**COMMENTS ON THE APPLICANT'S  
REVISED DRAFT DEVELOPMENT  
CONSENT ORDER, AND OTHER DEADLINE  
3 SUBMISSIONS**

**DEADLINE 4**

**IP Ref: 20018303**

**A63 Castle Street Improvement Scheme  
HULL  
TR010016**

## **5 6.2 Environmental Statement Volume 2 Figure 15.2 (APP-040)**

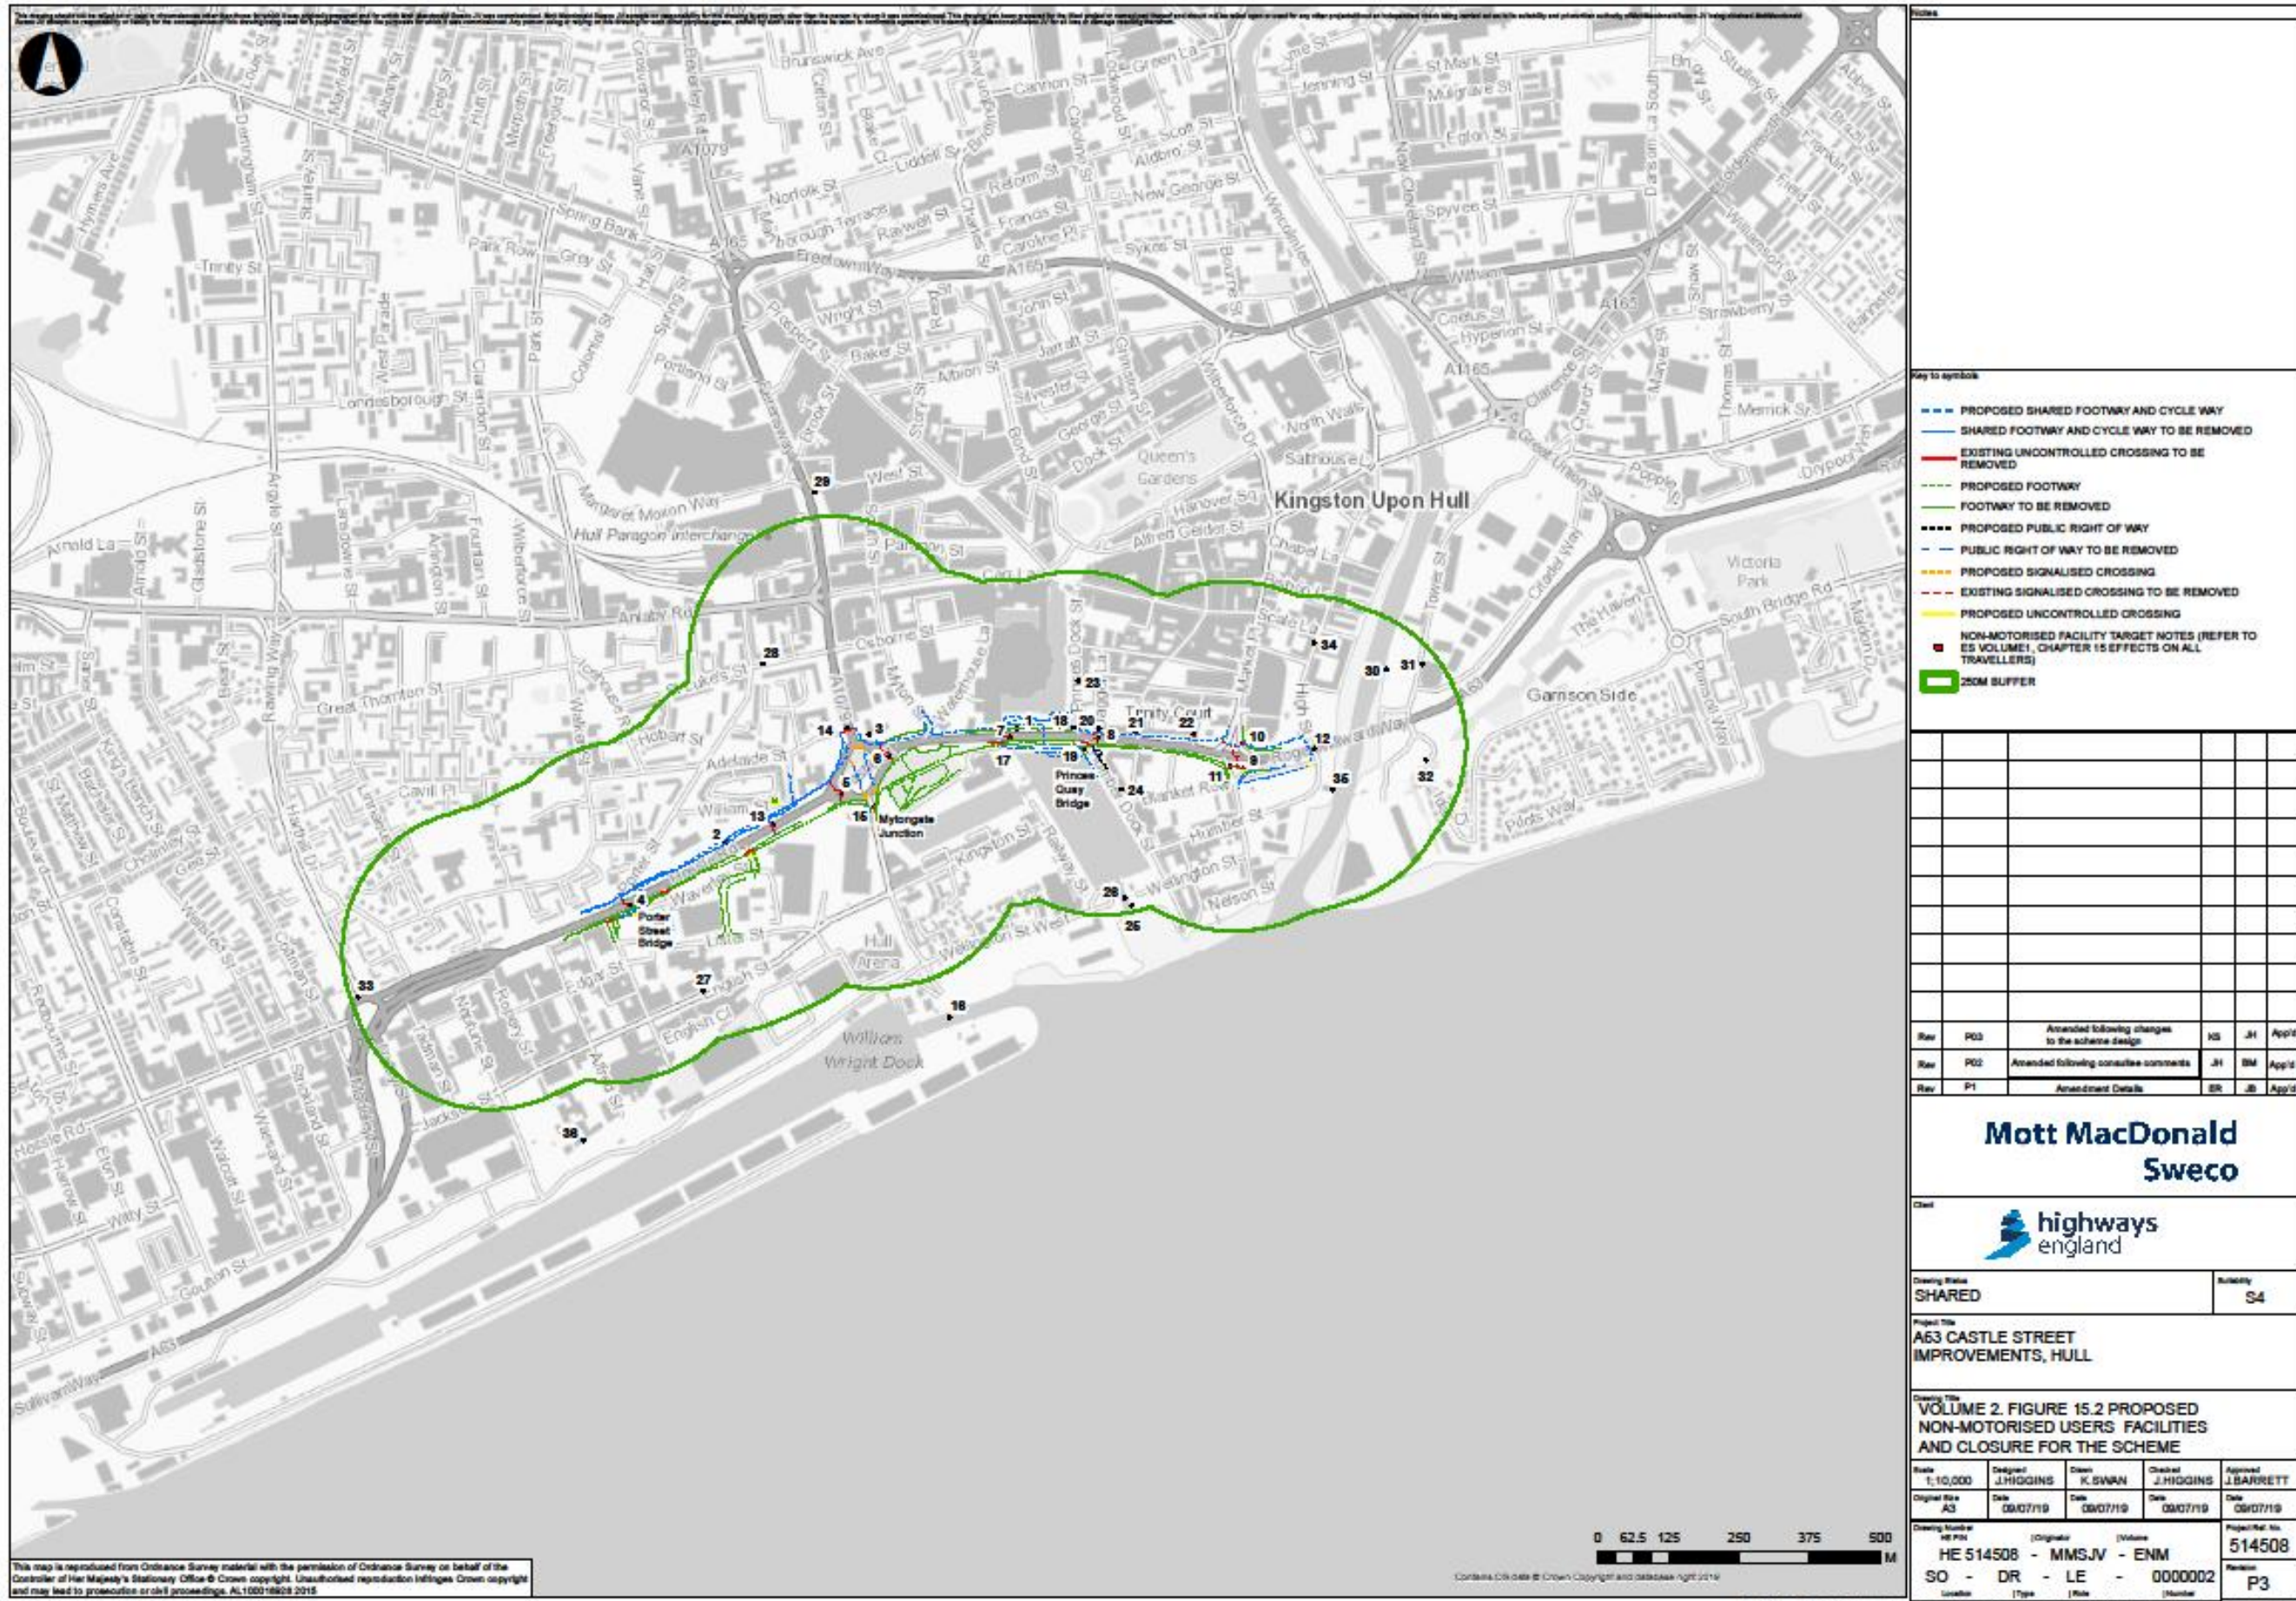
At paragraph 2.13.7 of the applicant’s submission, there is a lack of clarity around the intended provision for pedestrians and cyclists to cross Market Place and Queen Street in an east-west direction. The paragraph could be interpreted as meaning that the Council wishes to see the existing crossings retained in their current form, or

that a crossing facility of any type be retained in these locations at all. The NMU plans as originally submitted, and as revised and submitted, both depict the provision of uncontrolled pedestrian/cyclist crossing facilities. For the avoidance of doubt, the Council considers the provision of pedestrian/cycle crossing facilities in these locations as imperative to highway safety, connectivity, and the facilitation and encouragement of sustainable forms of transport.

The Council also considers that it is essential that the crossings in question are controlled, in order to ensure that the most vulnerable users are protected in an area of potential conflict with motorised traffic, and those with mobility issues or visual impairments in particular, some of whom stand to be disadvantaged by longer travel distances as a consequence of the scheme already, have the confidence to utilise such facilities and avoid yet further inconvenience.
